April 8, 2015

**Re: Juan Tabo Hills request for CLOMR
Engineer's Stamp Date-no stamp- (M21D018)**

Based upon the information provided in your submittal received 2-25-15, the above referenced CLOMR cannot be submitted to FEMA until the following comments are addressed:

PROJECT Twin Turbo Hills West
SUBJECT Section 3
BY _____ DATE _____
CHECKED _____ DATE _____
SHEET _____ OF _____

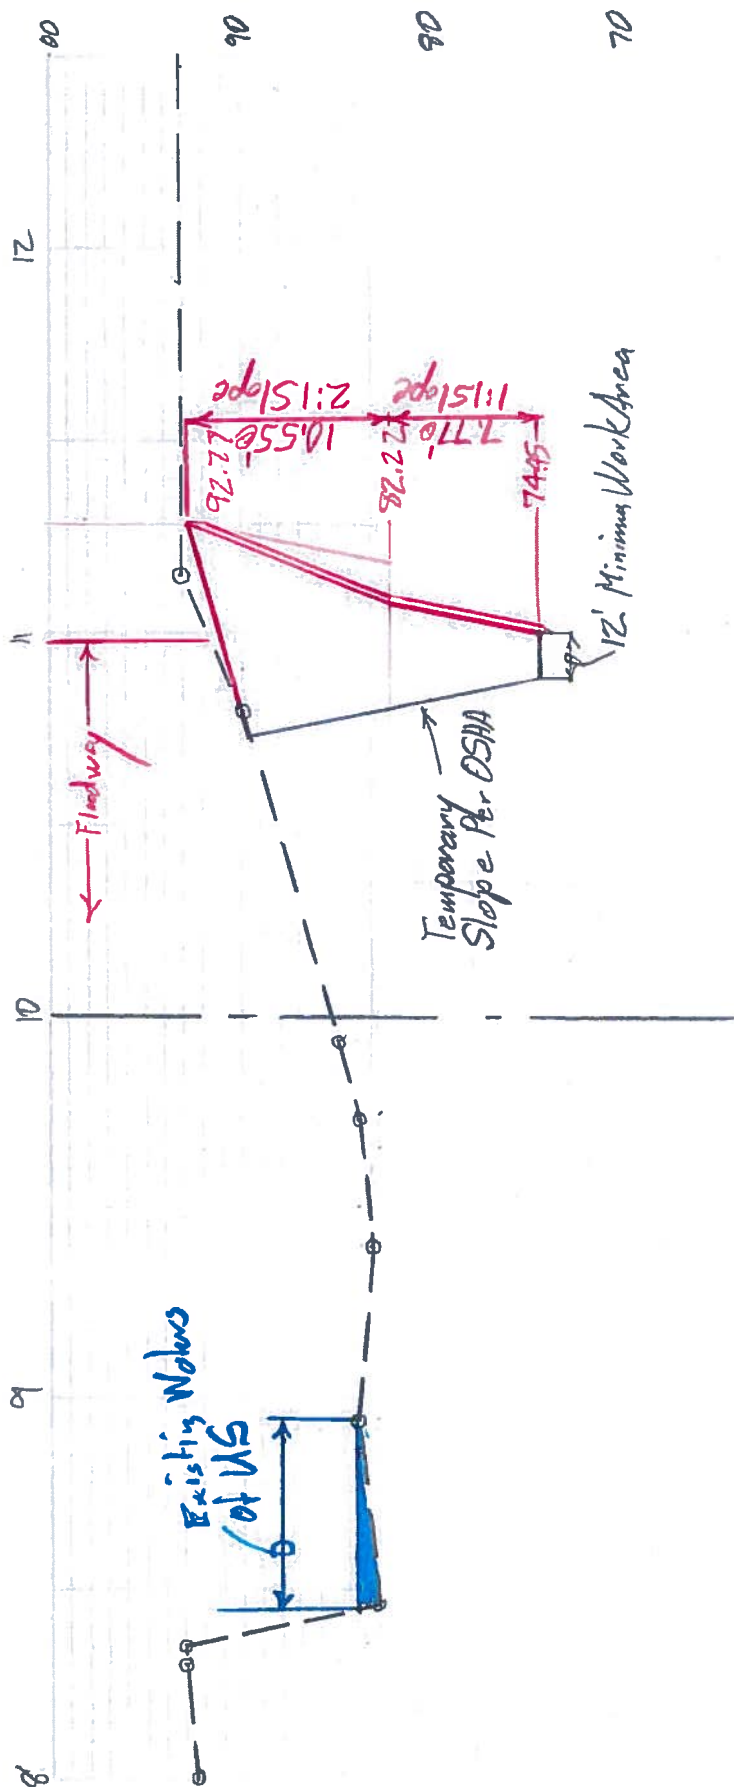
13. Show/discuss how this request will not create a flood zone behind the scour wall due to upland flows.
14. What is the purpose of the information in Sections 3 through 6? If they are cross-section of arroyo improvements, they should be drawn to scale and show existing and proposed grades.

**GRADING & DRAINAGE PLAN**

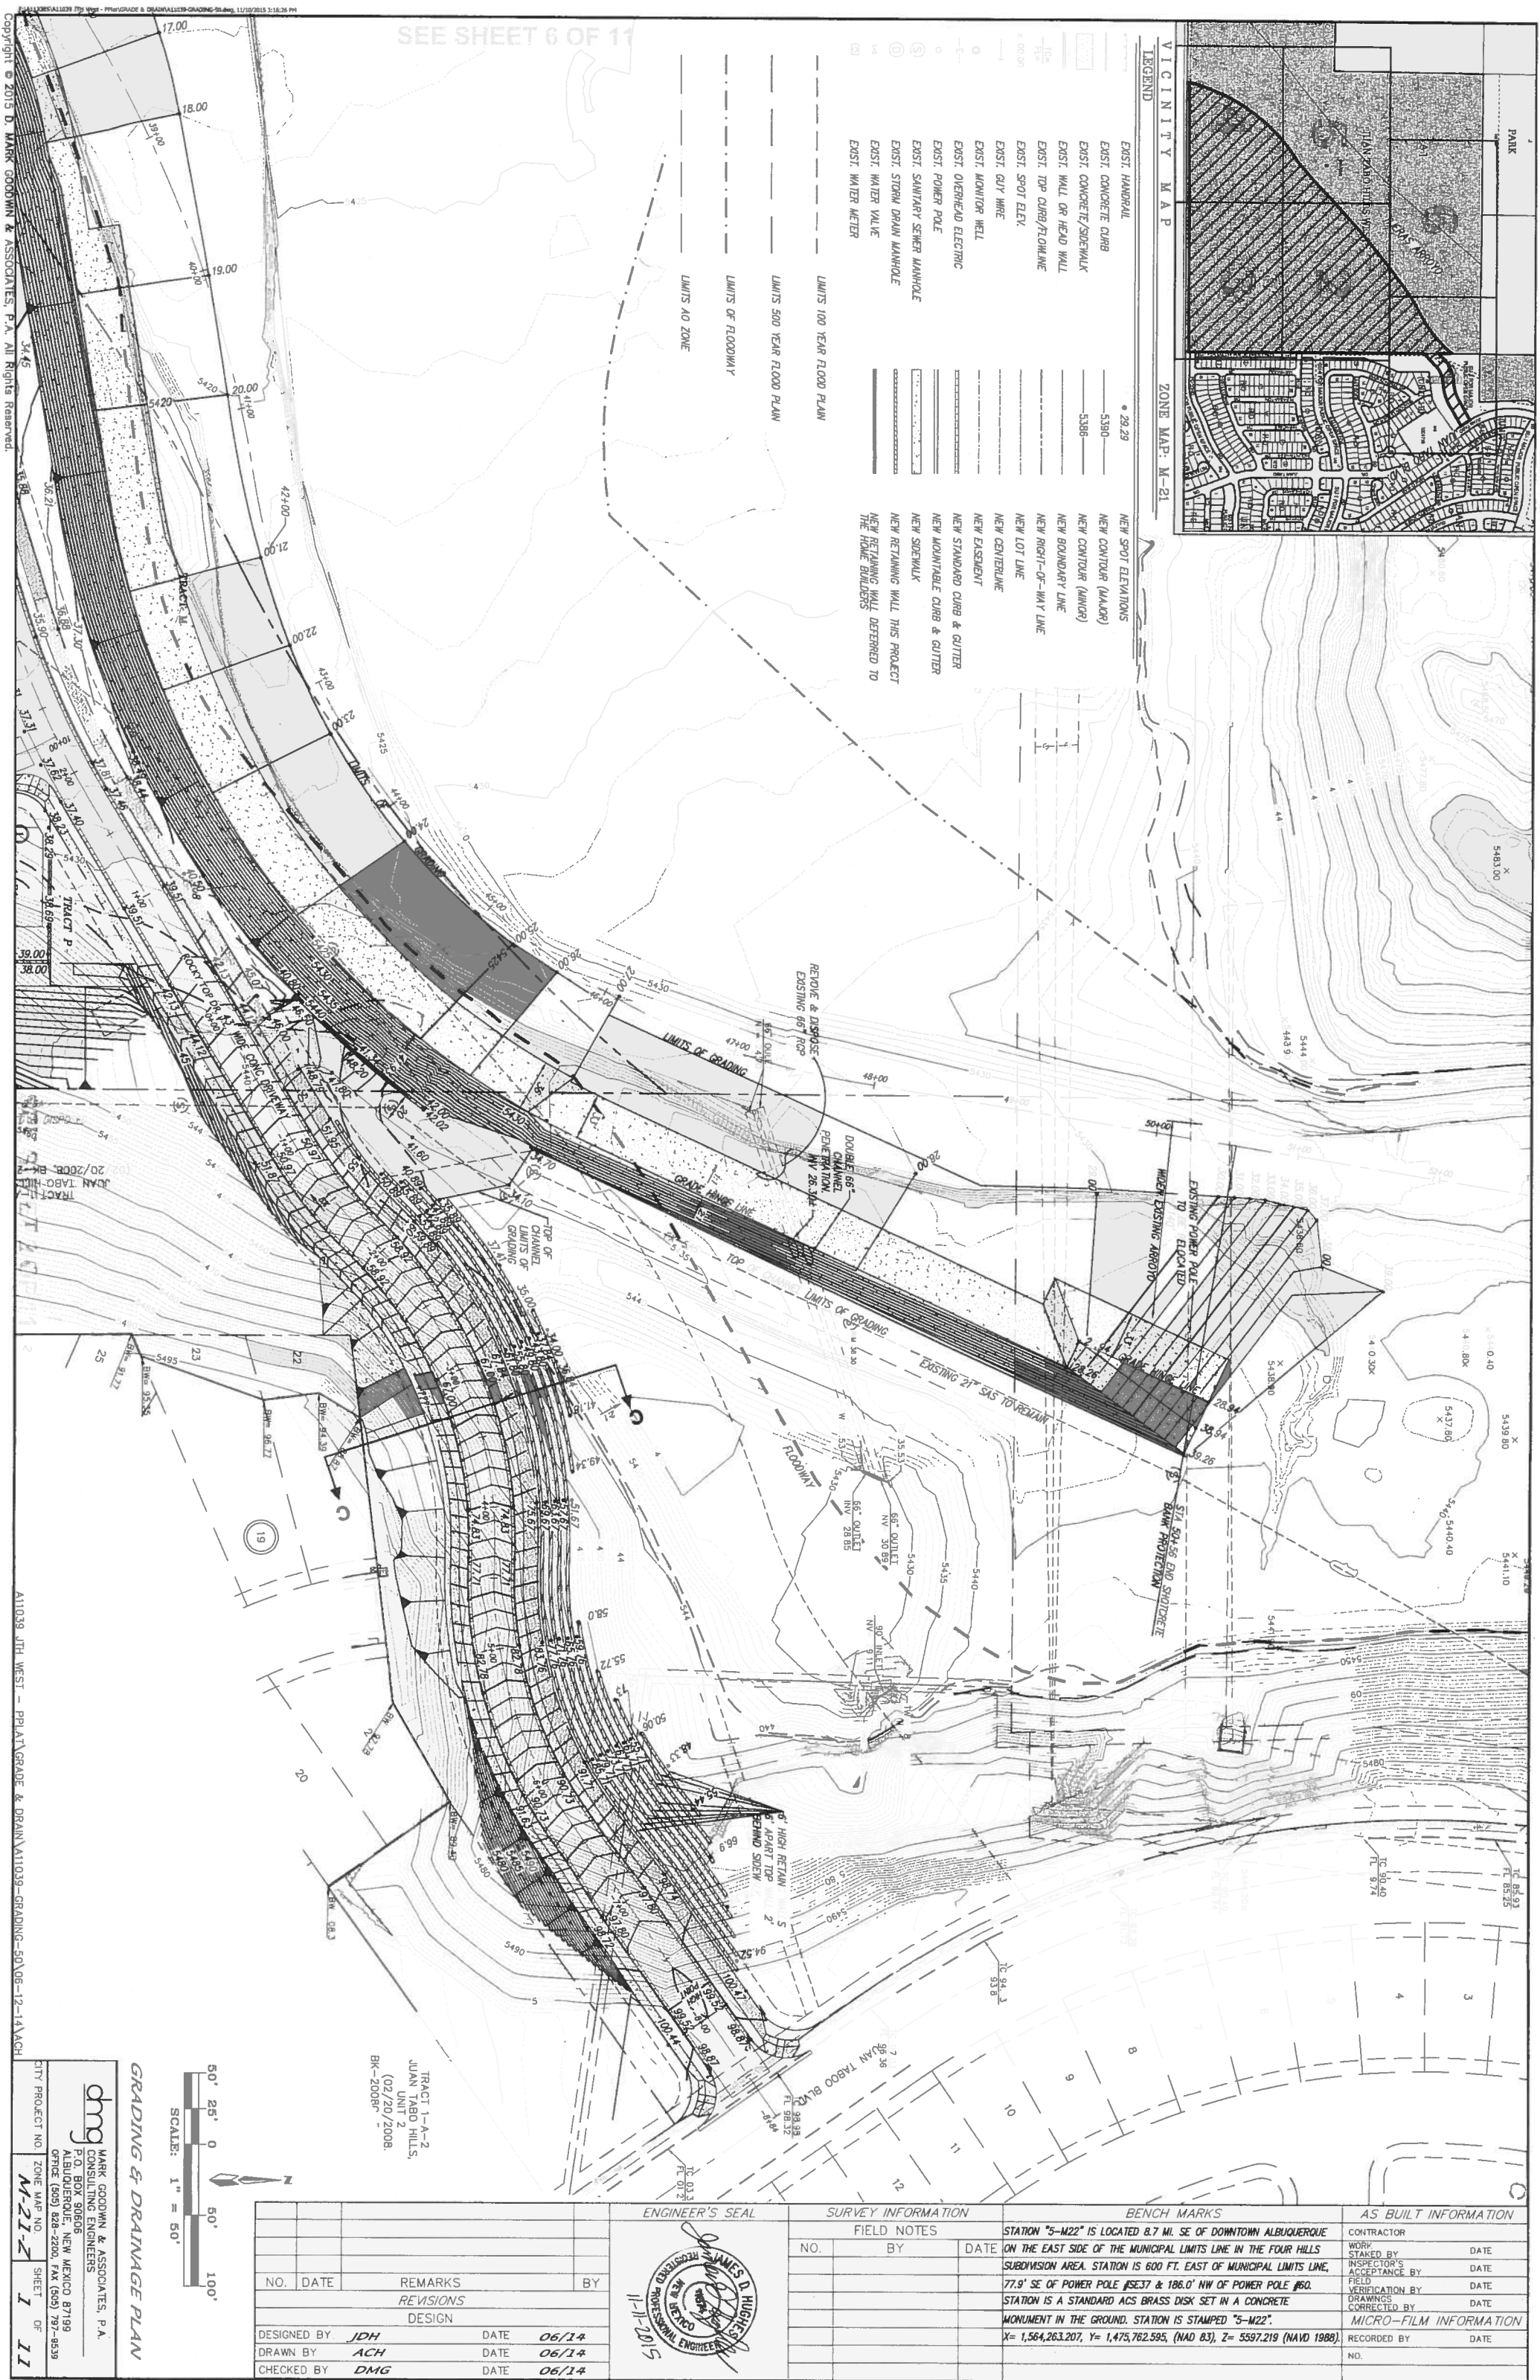
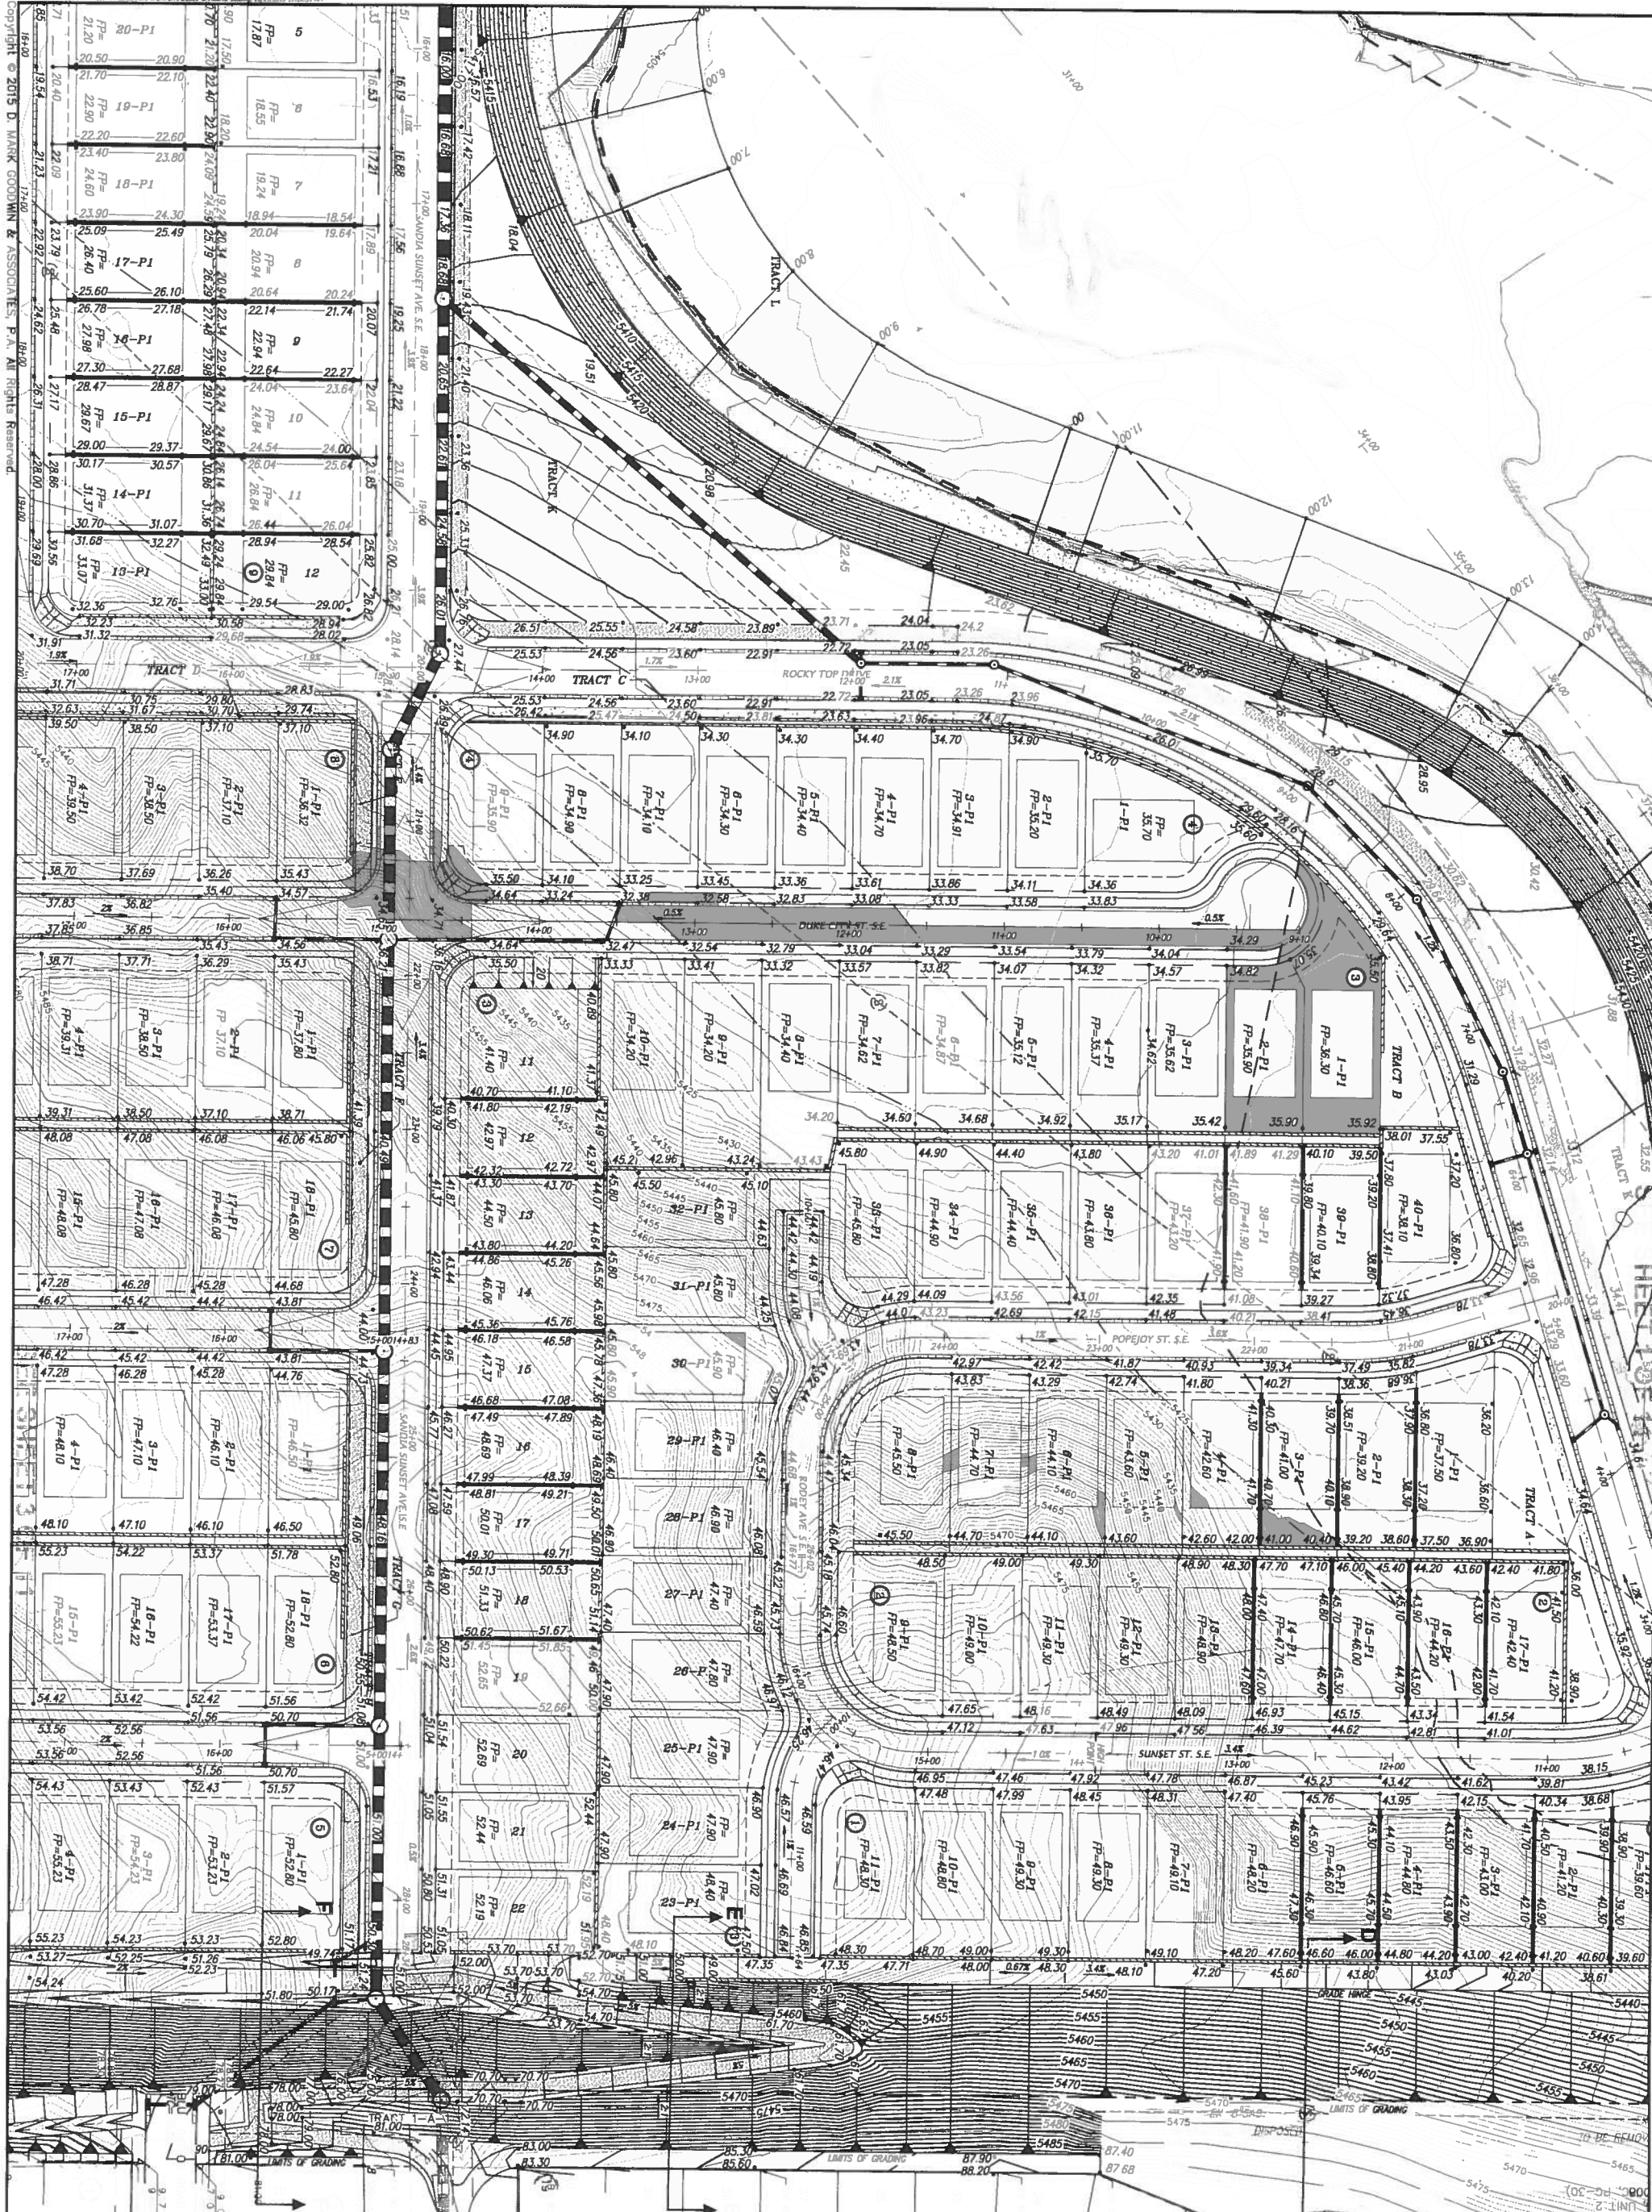
1. The grading plan for the subdivision and the Bank Protection Design Analysis report should be included with this CLOMR request.
2. A brief review of the grading plan revealed that it was difficult to determine the amount of fill because existing contours were not labeled and spot elevations were not provided.

3. The grading plan should show the flood zone(s) and floodway where appropriate.
4. Provide the Annexation agreement. This area is still shown in the County.
